**RE: Draft Environmental Assessment for Proposed Capital Wind Farm II (MP 10_0135) – Part
3A Environmental Planning & Assessment Act 1979**

Comments on the Environmental Assessment for Capital Windfarm II

Figure 2a. Vegetation map and location of survey plots (north). (N = native pasture with some native grassland.

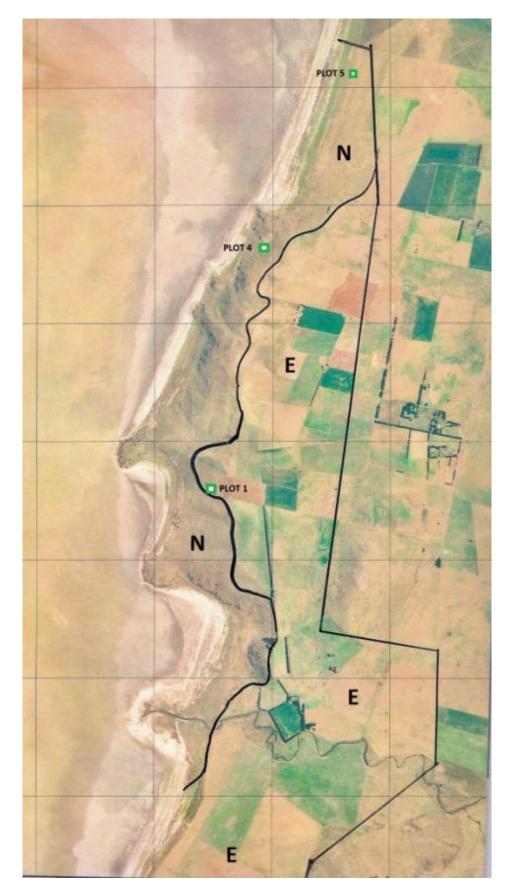
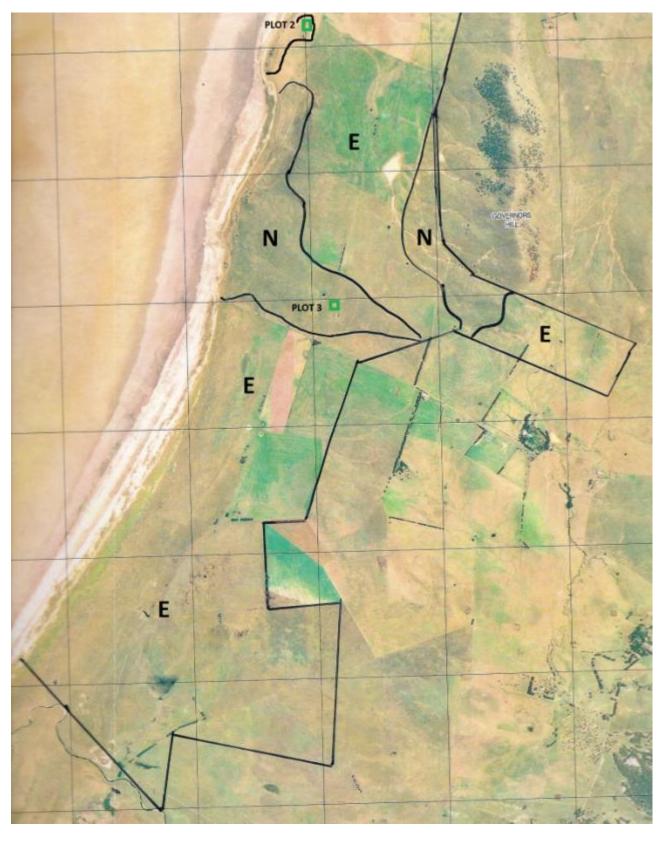
DECCW consider the mapping of EEC and high conservation values within the F&F assessment to be inadequate. DECCW request the proponent reproduce Figure 3 within the F&F assessment to an appropriate scale that clearly shows the development foot print and areas of grassland across the site. DECCW refer DoP to section 2 of the DGEARS.

DECCW recommend the EA should also include figures that clearly show the development footprint against the location of EEC and other high conservation values such as rock outcrops across the site.
